# CITY OF ALBUQUERQUE

October 14, 2014

**Re: Santuario De San Martin De Porres Church  
Scott McGee's Engineer's Stamp 10-1-14 (M10D002)**

GRADING AND DRAINAGE PLAN

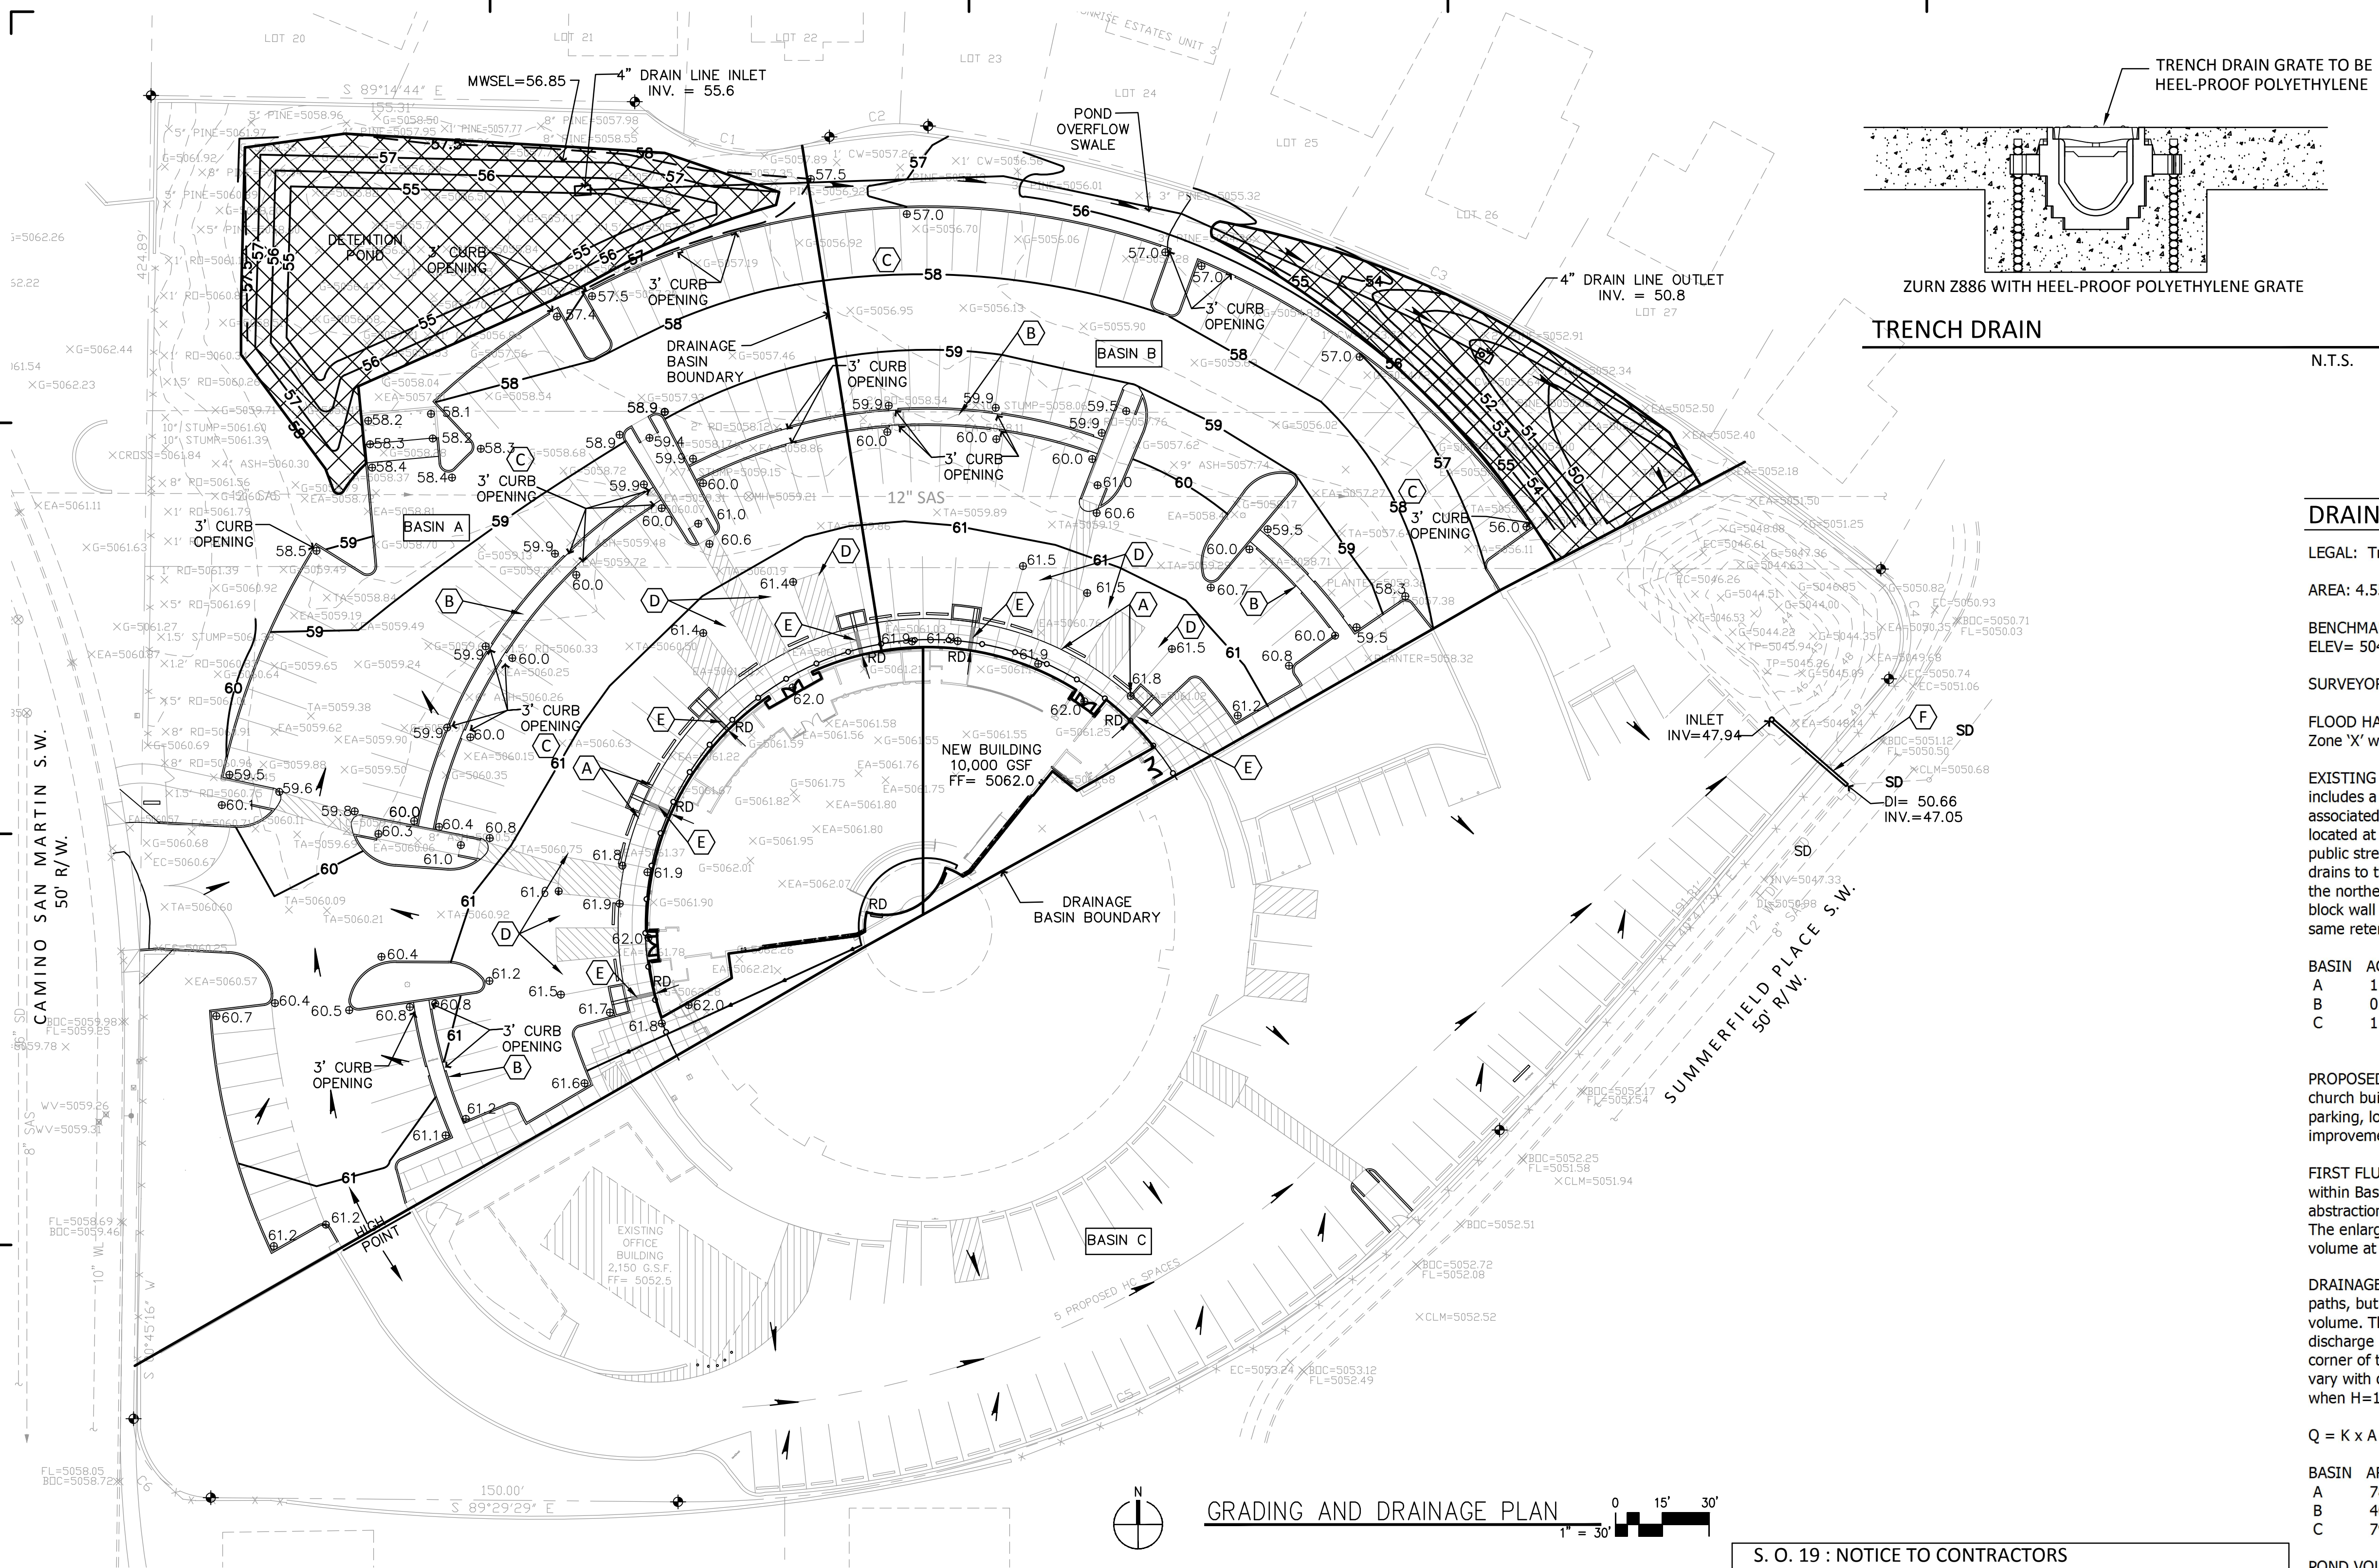
1. The existing site produces 16.0 cfs and has retention ponds. While the proposed solution is to discharge 15.2 cfs which is less than the 16.0 cfs currently produced, the proposed discharge is still 15.2 cfs more than historic discharge.

There are several options for this site. One is to continue to do full retention on site for all flows. Another is to discharge 0.1 cfs/acre or less. Another is to analyze the contributing basin and capacity of the 24 inch storm drain in Unser and discharge less than that amount.

2. In your narrative, you are providing 750 cf of storage for the First Flush at a 6 inch depth. However, the bottom of the western pond is at 54.00 and the invert out is 54.20 which is not 6 inches of depth. Provide the 6 inches of depth in the pond.

3. Quantify the how much area is being provided by the 3" by 3" holes in the wall. Demonstrate the flow is not being restricted by the wall.
4. How high is the maximum water surface elevation in the parking lot by the sidewalk culvert? How did you arrive at 4.6 cfs for each sidewalk culvert? The finished floor of the existing main building 52.4 from a plan submitted by you in 2010. The wse should be below that.

5. CoA Standard Drawing 2236 is referenced in the drawings. Include on the plan the Modified Section B-B which is attached.
6. Many proposed spots seem to be turned off. Proposed improvements and existing grades have the same line weight. A 60 contour and a 57 contour seem to disappear. Please revise accordingly.
